From: drew Jones [REDACTED]
Sent: 09 October 2019 18:14
To: Simon Davis <Simon.Davis@arun.gov.uk>
Subject: Re: Y/53/19/NMA - North Barn, Hoe Lane

From: Simon Davis
Sent: 30 August 2019 14:13
To: 'drew Jones' [REDACTED]
Subject: Y/53/19/NMA - North Barn, Hoe Lane

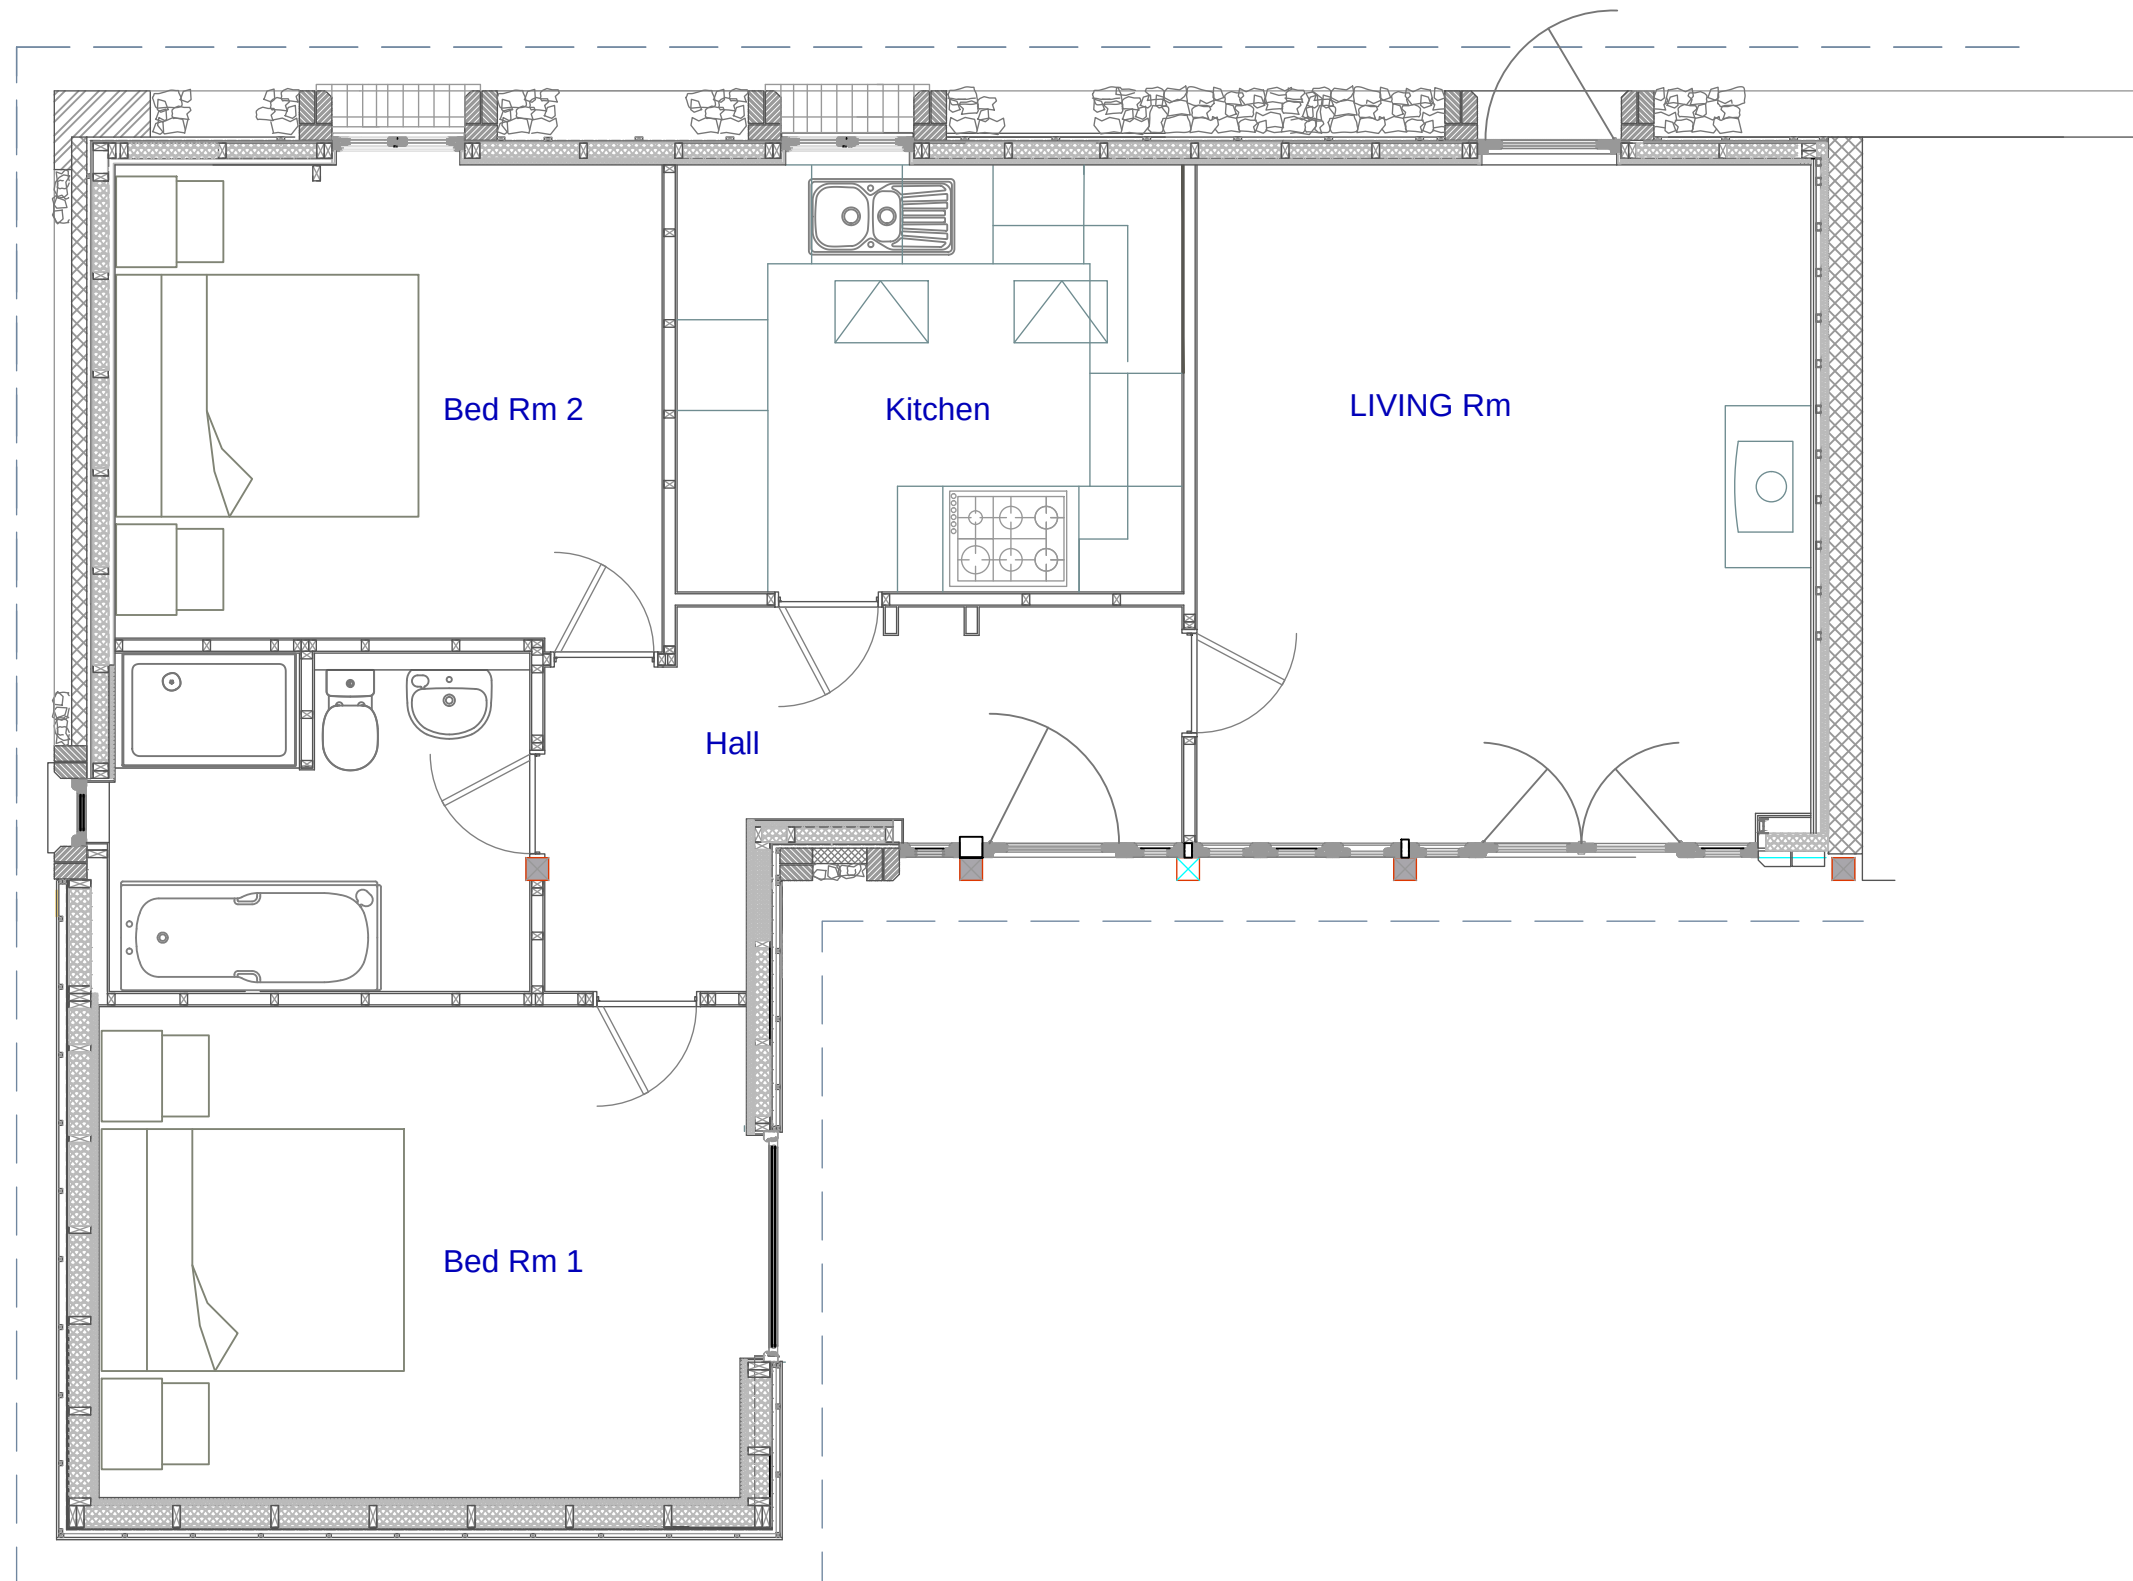
I have today discussed this matter with our Conservation Officer. He does not object to the use of timber boarding or the setting of the windows/doors behind the existing timber posts. However, he does have some concerns with the changes to the 'french door' windows on the north elevation. Although he prefers that there is now no longer a gap between the top of the door and the eaves, he does not like the fact that you can tell from looking at the windows where the opening is. He prefers the uniformity of the windows/doors approved on the original scheme. If you are able to change this then we can accept the scheme as a NMA. Please feel free to call to discuss.
